Surrey County Council (IP 20023014) Written Summaries of Oral Submissions put at the Issue Specific Hearing held between 15 and 16 January 2020

Figure 4.1 Composition of traffic on B2215 Portsmouth Road (north)

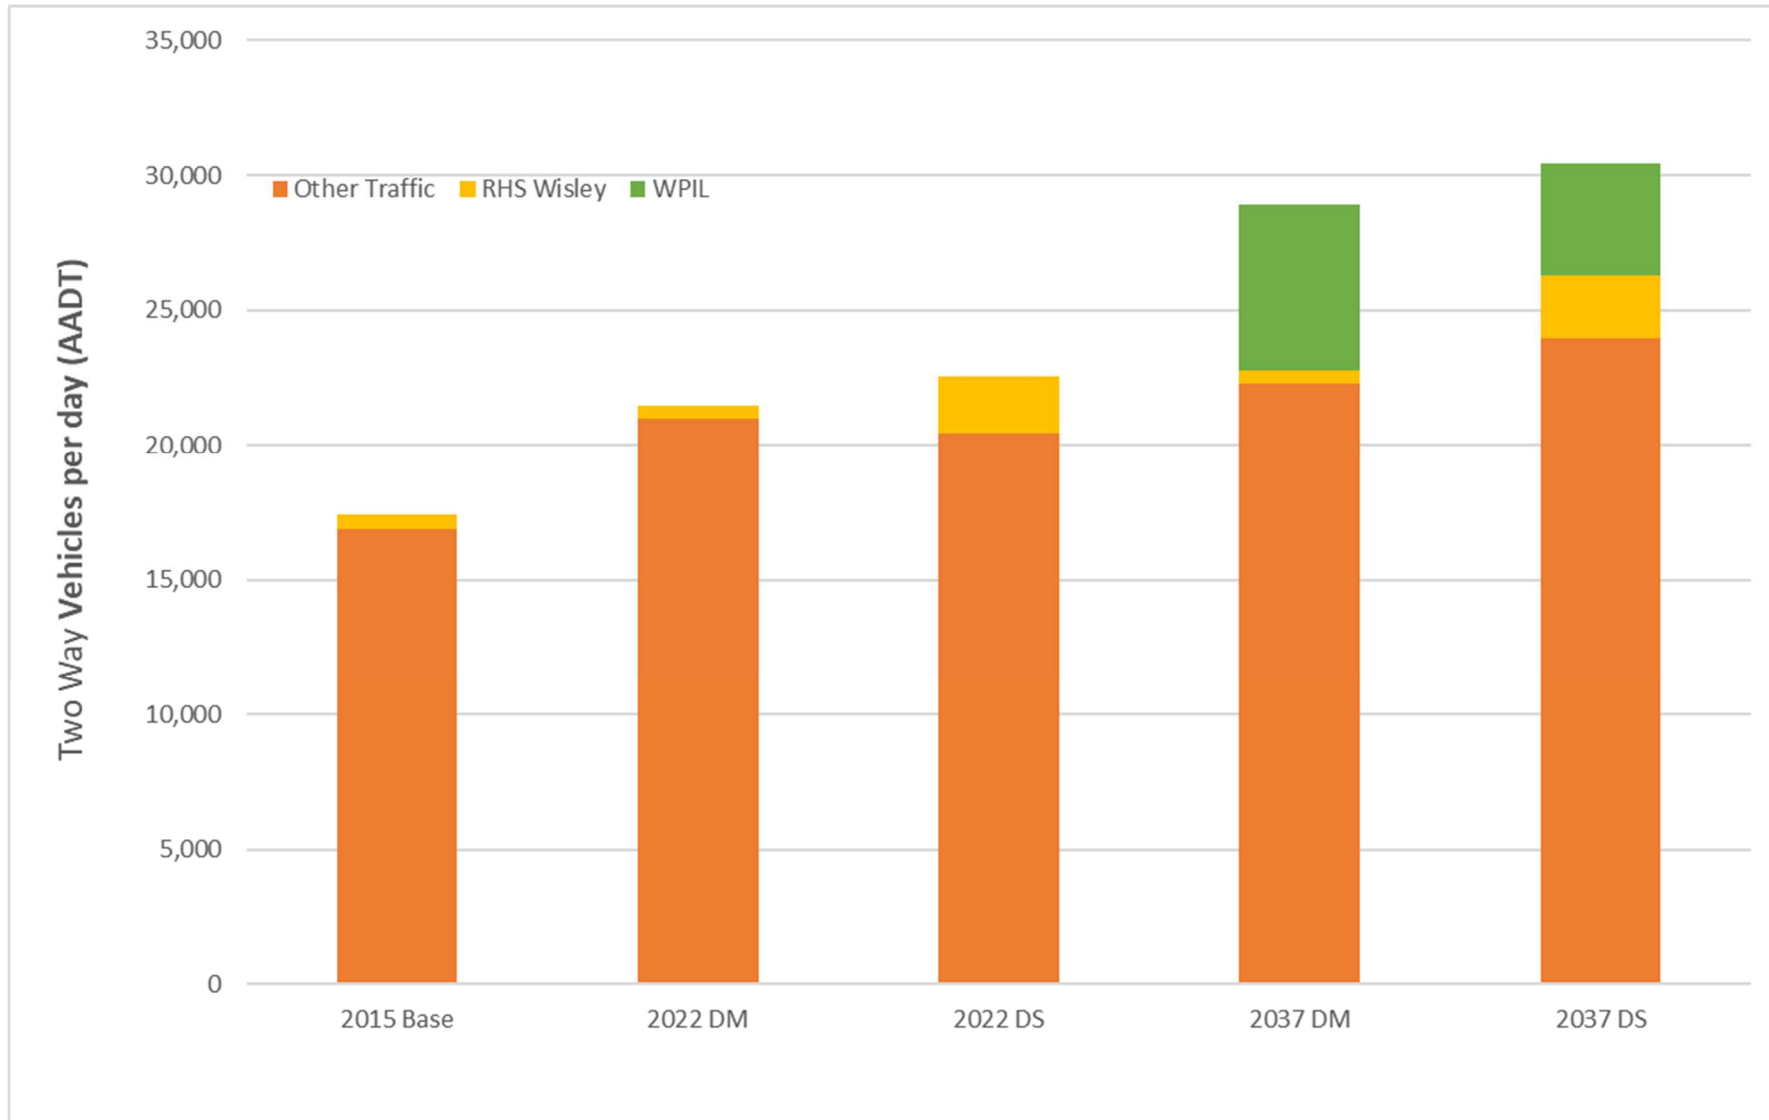
The Council made further comment on the Transport Assessment Supplementary Information Report (Rep2-011), specifically table 4.1. It was suggested that the increased traffic through Ripley was the equivalent in impact terms of building 1500 homes in Ripley and not providing any mitigation. Detailed information on concerns relating to the impact on Ripley is provided within the Joint Councils' LIR (Rep2-047).
